PLANNING DEPARTMENT – Development Review Services

August 3, 2015

**RE: Western United Electric
Conceptual Grading and Drainage Plan
Engineer's Stamp Date 7-6-2015 (H10D029)**

WESTERN UNITED ELECTRIC
GRADING AND DRAINAGE PLAN

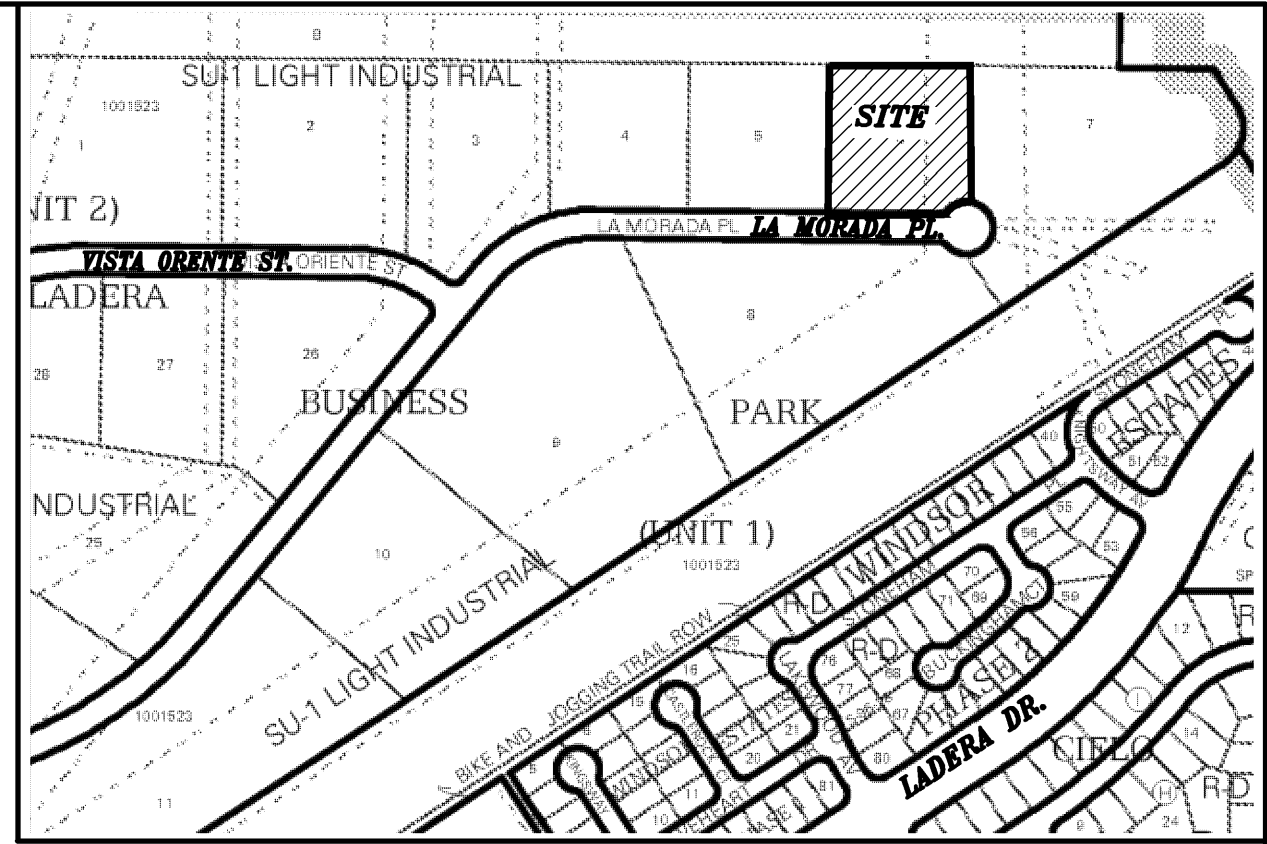
1. Due to the comments from PNM regarding the high-voltage transmission lines, PNM must approve the site plan prior to DRB action.
2. Why is there 1ft curb on the west side rather than standard 6" curb?
3. Show roof discharge arrows
4. Provide excerpts/documentation from DMP showing free discharge to La Morada is programmed for this site.
5. Provide runoff calculations. What is the discharge rate? What is the volume discharging into the pond at NE corner? Show land treatment areas/percentages in the calculations.
6. How will pond at NE corner discharge to street? Is it a retention pond? If so, 10-day volume required, as well as an emergency overflow.
7. Indicate the pond volumes on the plan. Label Ponds, ie. Pond 1, Pond 2.
8. Is the pond in SE corner a detention or retention pond? If detention, how will Pond corner discharge to SW culvert? Is the culvert an emergency overflow?
